5. Landscape & Visual Steeple Renewables Project

November 2025

**FIELDS FOR
FARMING**

VIEWPOINT 1B

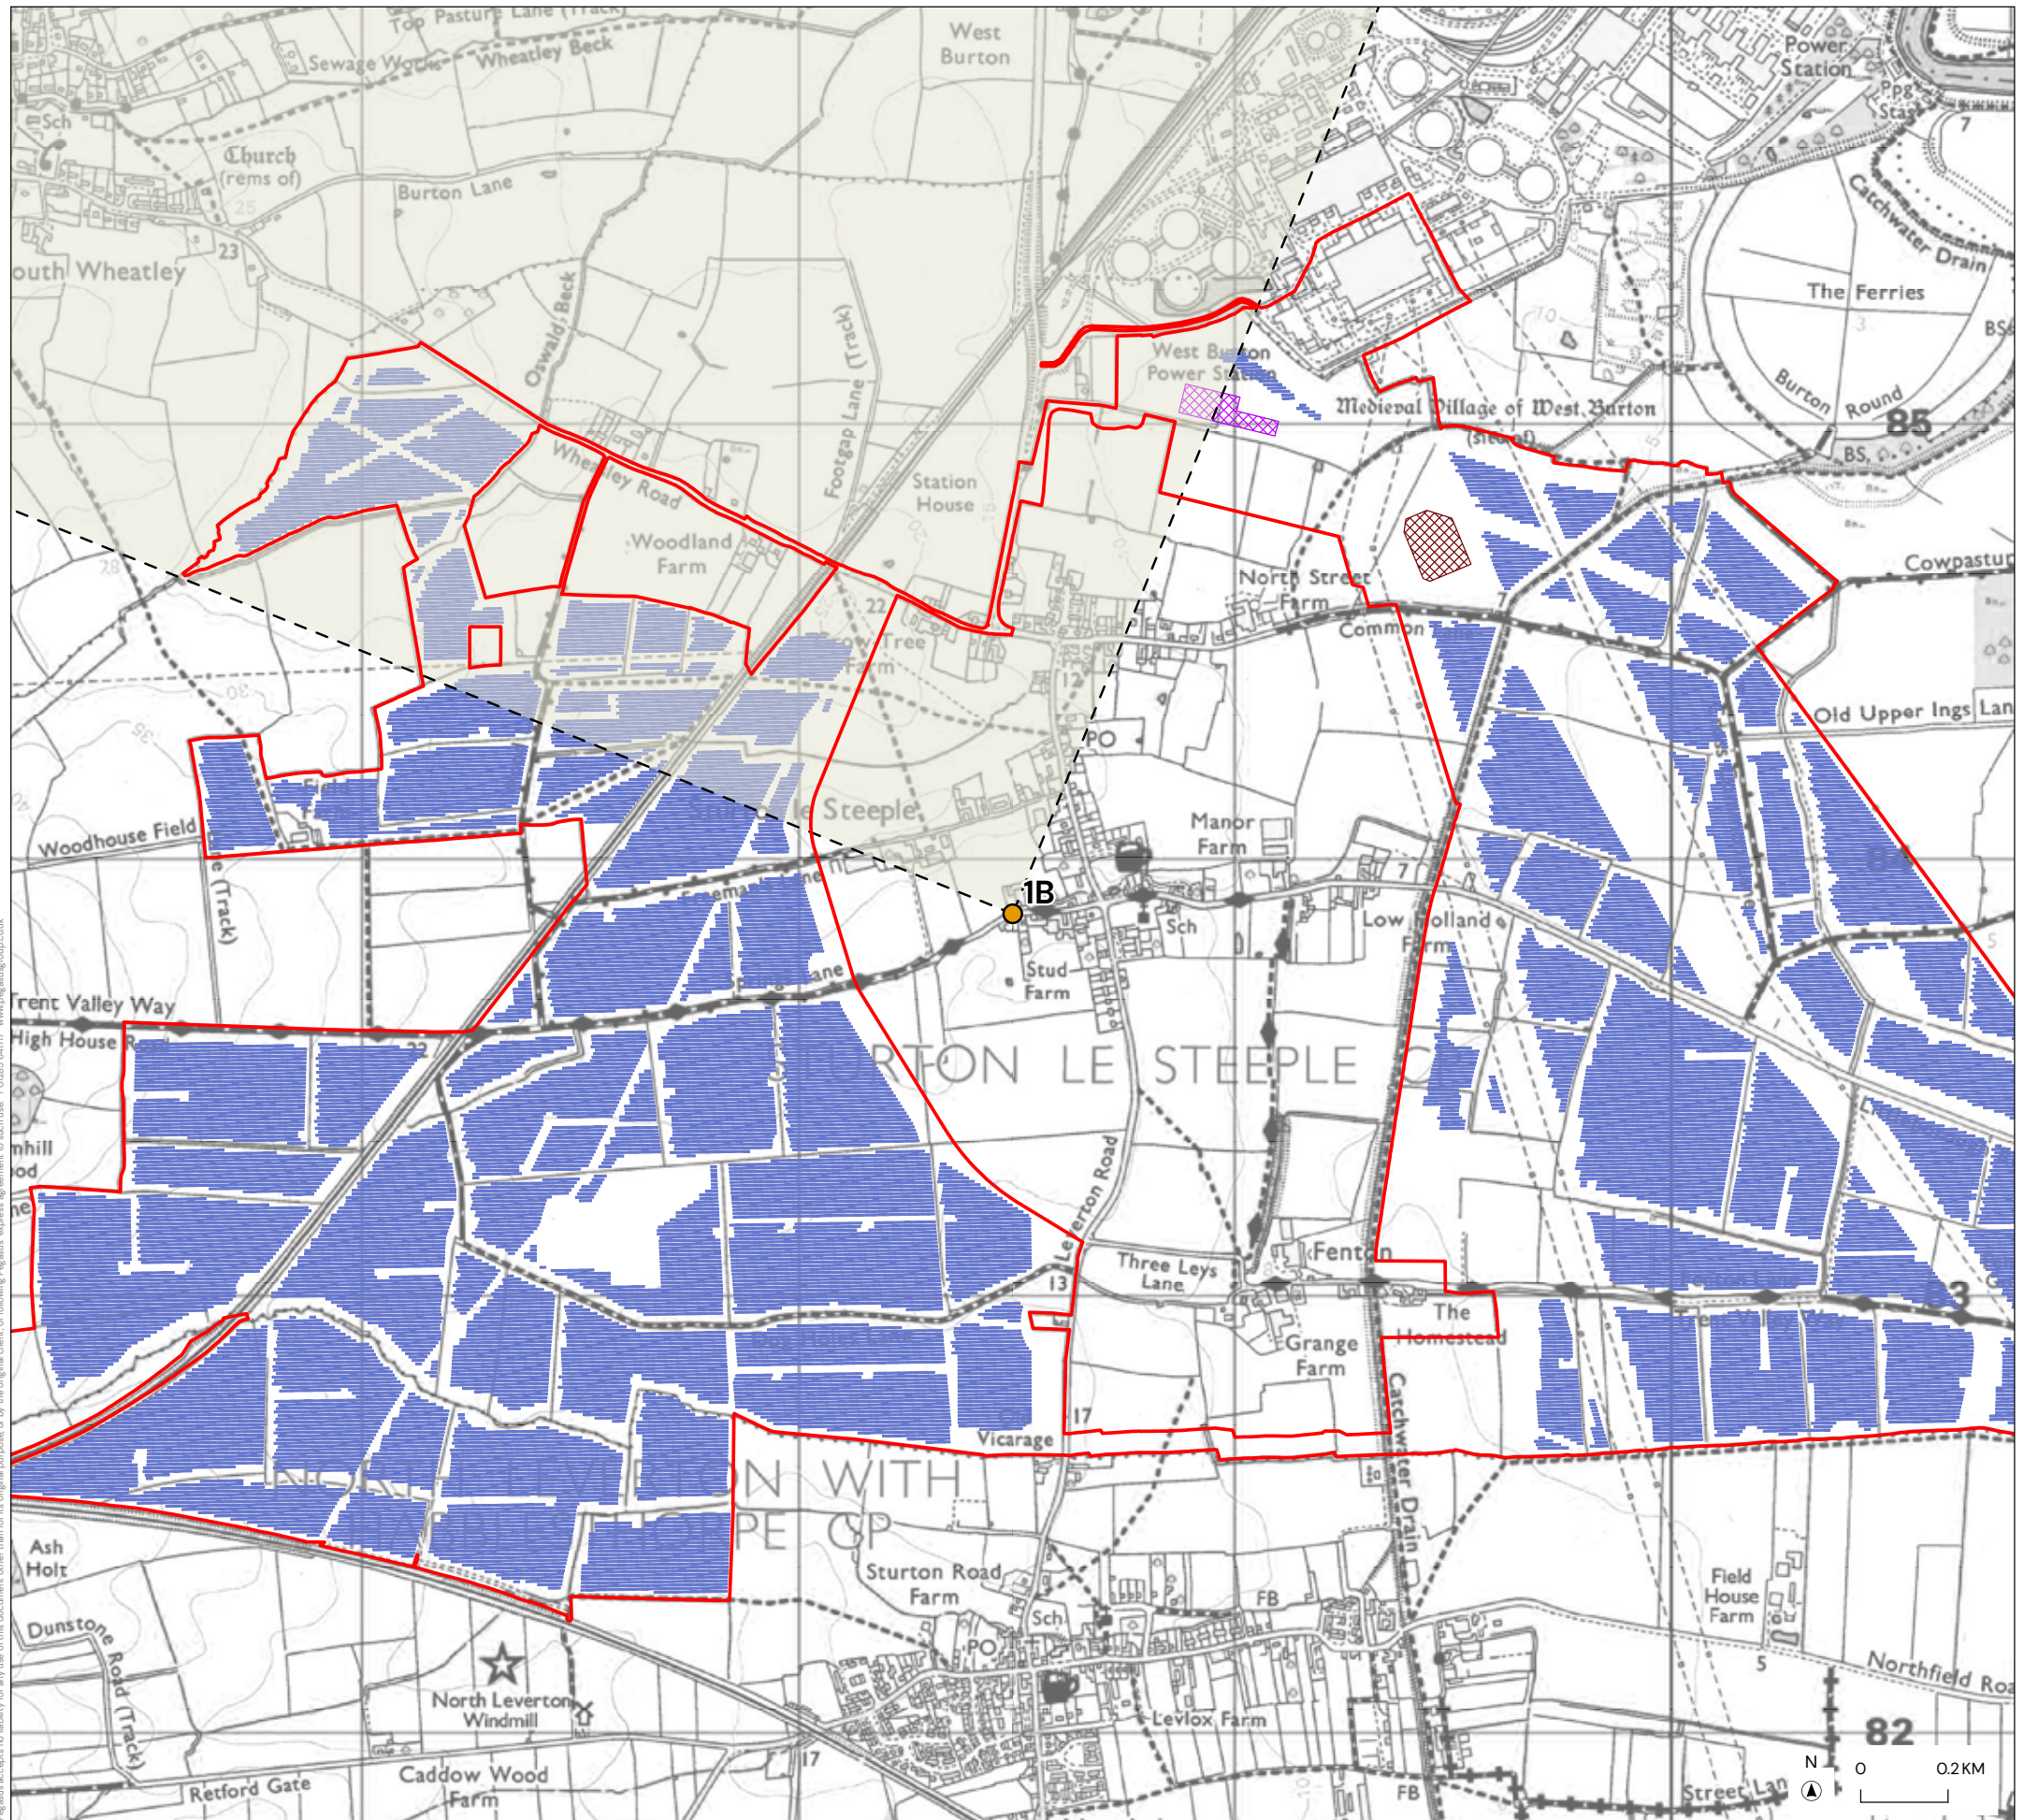
VP 1A & 1B represent Trent Valley Way – Solar is not proposed in these two fields (these fields are not in the red-line. The site is beyond the farm buildings depicted).

VIEWPOINT 6A

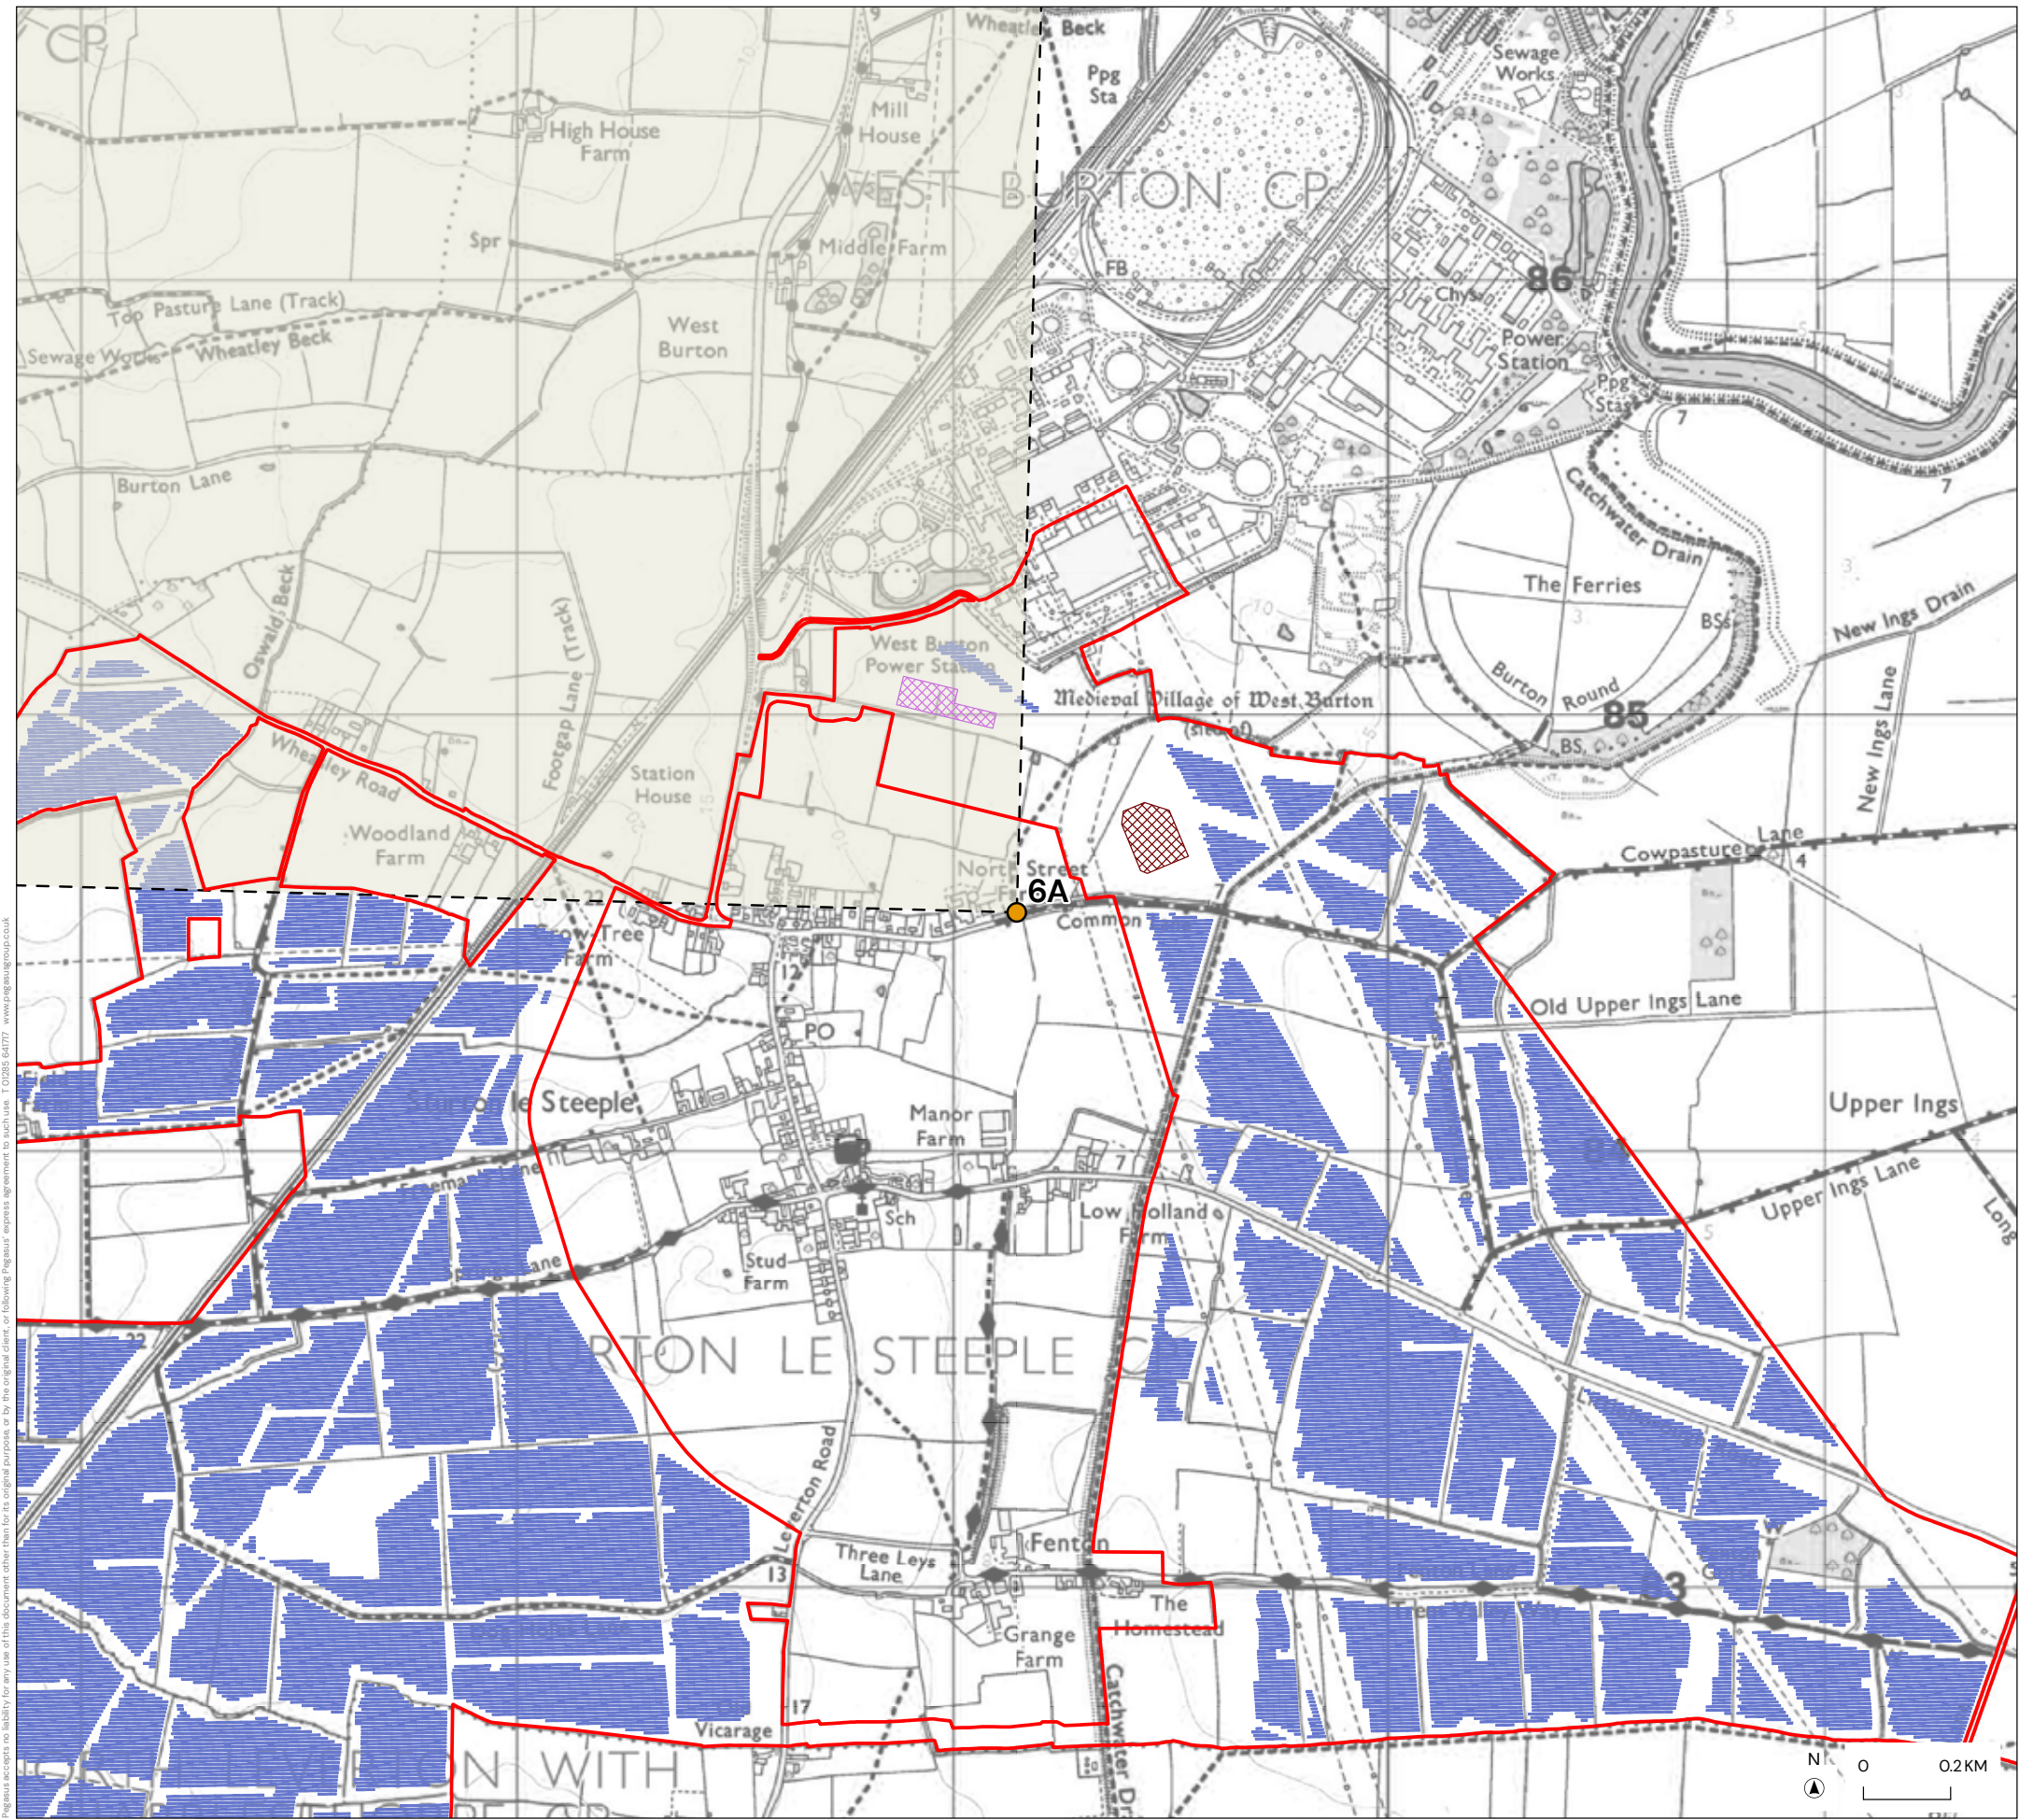
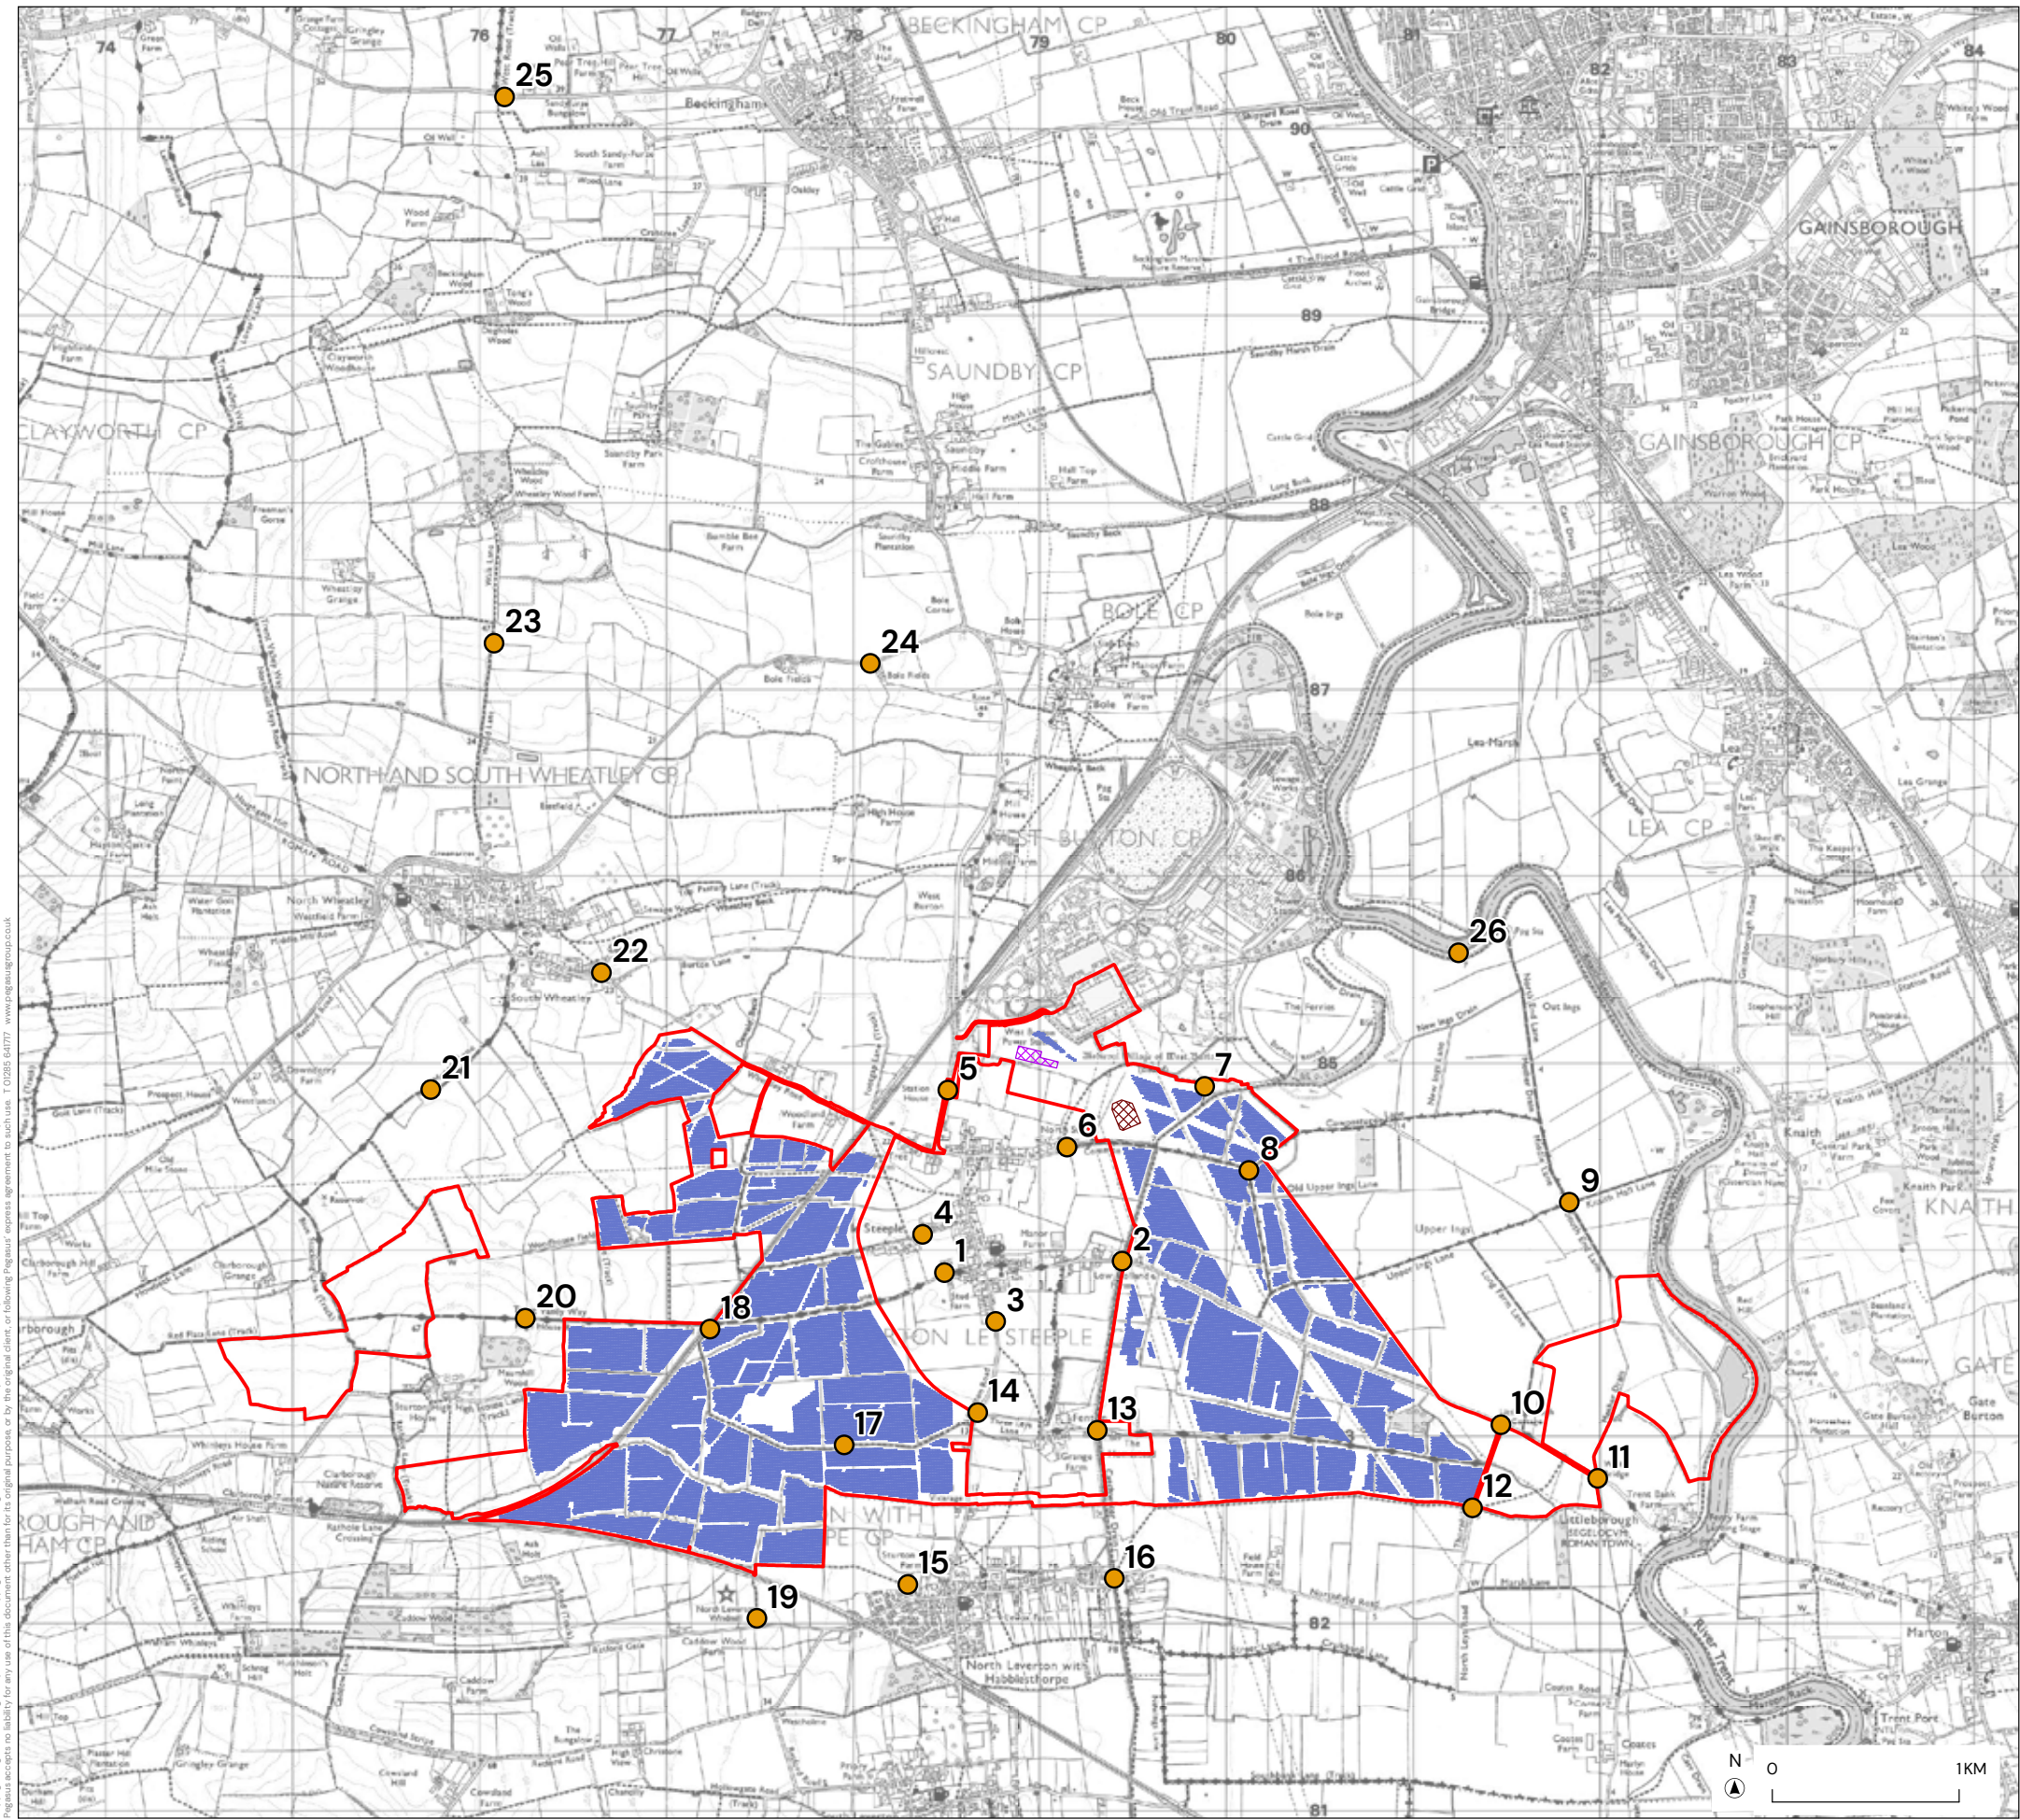
VP 6a, 6b, 12, 13a, 13b, 14b all show West Burton Cooling Towers in the backdrop, and continue to do so through out, these towers will be gone by 2026/2027. By turning 180 degrees and taking photographs would have given a far better reflection of the area being affected by the development and would have shown how open and rural the landscape and views actually are.
